S.455 (1A) Modification – Landscape Statement

This letter has been prepared by Aspect Studios on behalf of WL Developer Pty Ltd (the applicant) with regards to a Section 4.55 (1A) application to modify the State Significant Development SSD 10437 – Waterloo Metro Quarter OSD Southern Precinct.

General Arrangement: Building 3

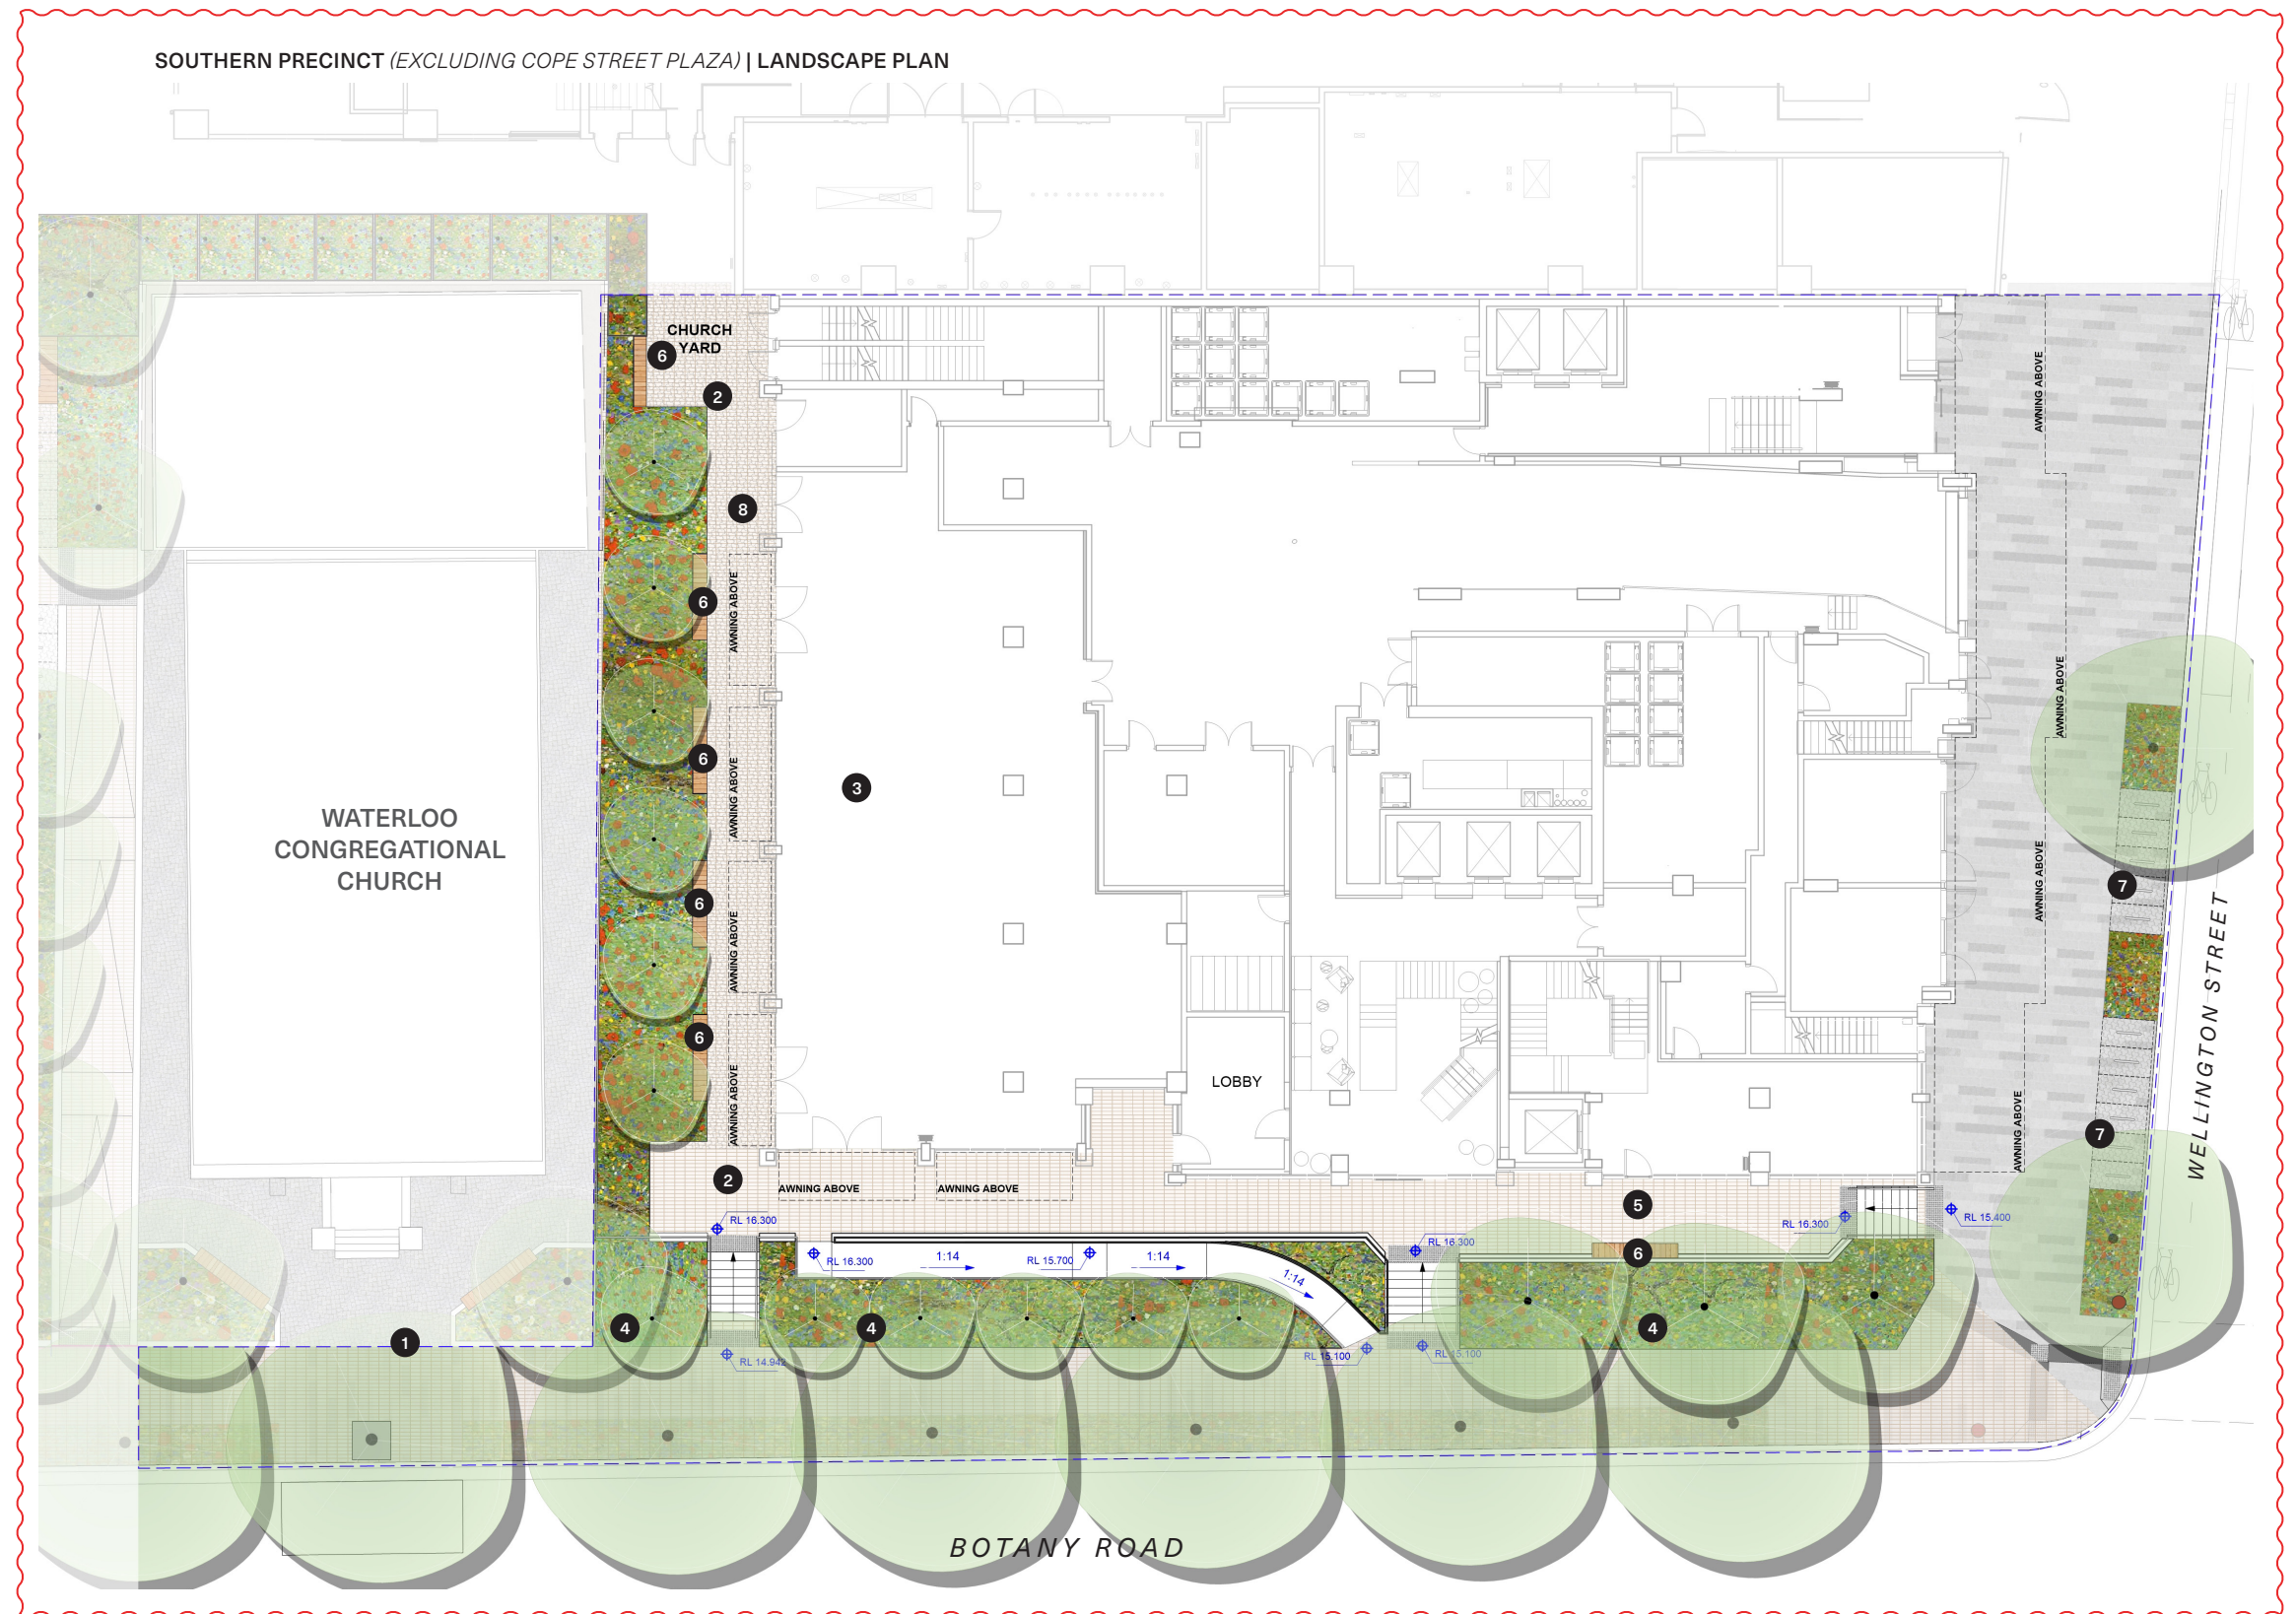
<p>2</p>		<p><u>Rear of Waterloo Congregational Church Boundary</u></p> <ul style="list-style-type: none"> - Additional landscape area to rear of church - Raised steel planters removed and 7 no. bike racks (14 spaces) provided. - Raised planter seating wall to corner to provide security protection to station building.
<p>3</p>		<p><u>Building 3 – Church Yard</u></p> <ul style="list-style-type: none"> - Reduction in retaining wall height alongside church to improve site visibility and potential construction impacts. - Creation of landscape terraces to give the church access to planting at lower height than previously designed. - Bike parking added - Seating and stairs updated to align to new landscape geometry - No change to tree numbers or canopy coverage

Level 2 | Communal Terrace

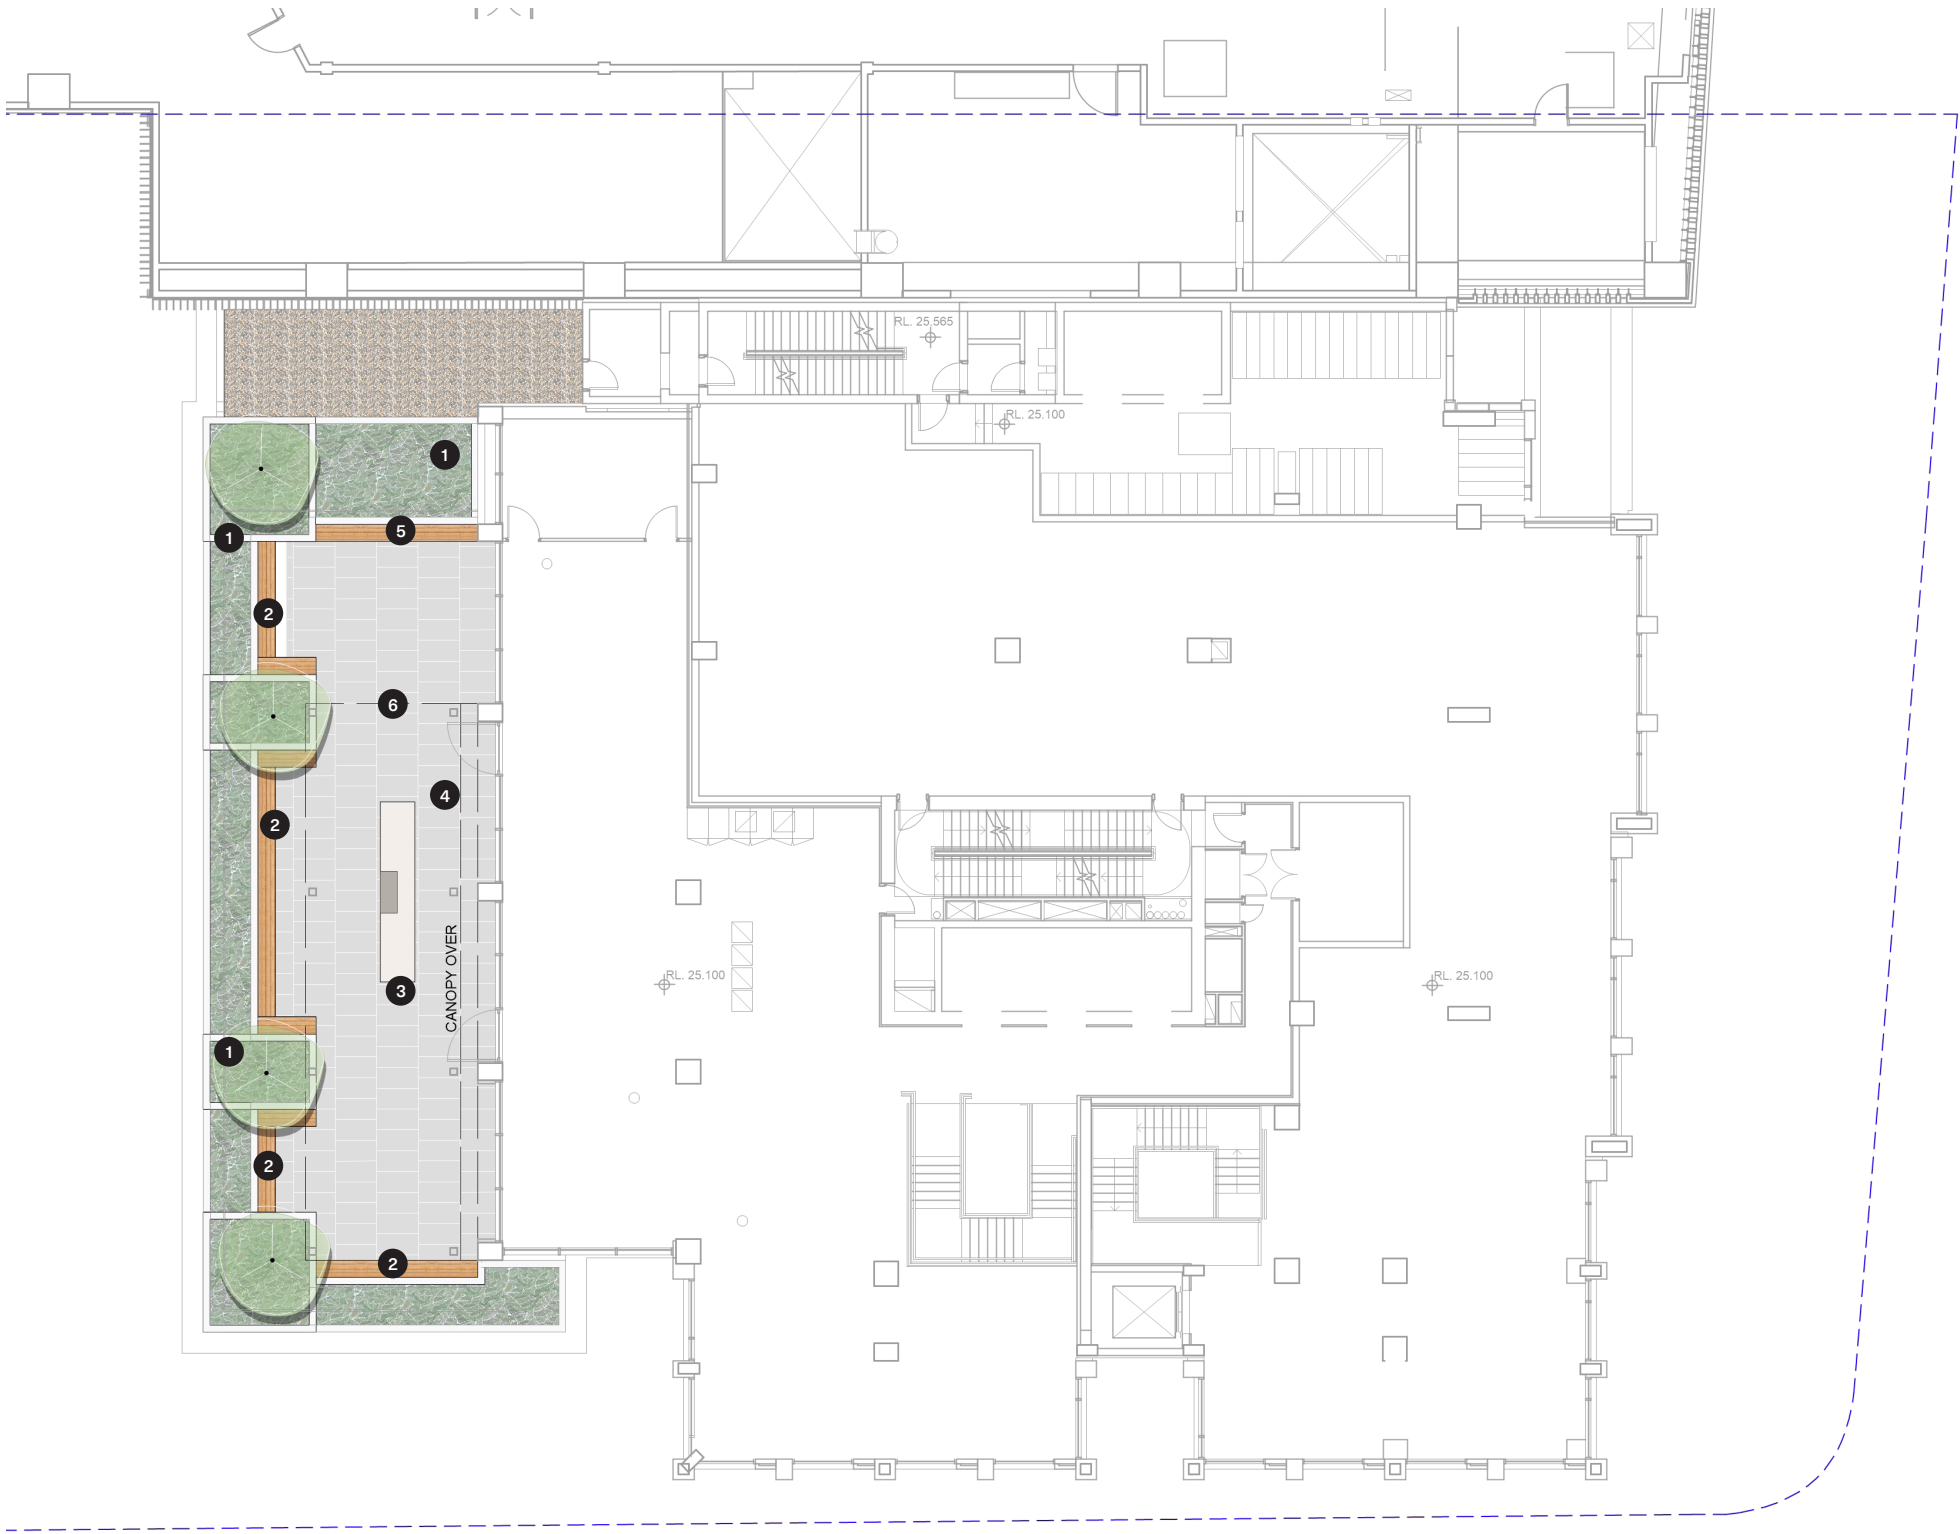
The site plan shows the layout of the Level 2 Terrace. A red dashed line outlines the terrace area. Key features include:

- Proposed Tree Locations (Green Circles):**
 - MP1 SCREEN (Top left)
 - MP1 (Bottom left)
 - PV8 (Top right)
 - PV8 (Bottom right)
- Tree Removals (Blue Circles with 'X'):**
 - MP1 (Top left)
 - MP1 (Bottom left)
 - PV8 (Top right)
 - PV8 (Bottom right)
- Other Labels:**
 - BBT (Top center)
 - BBQ (Center right)
 - MP1 (Bottom right)
 - BBQ (Bottom center)
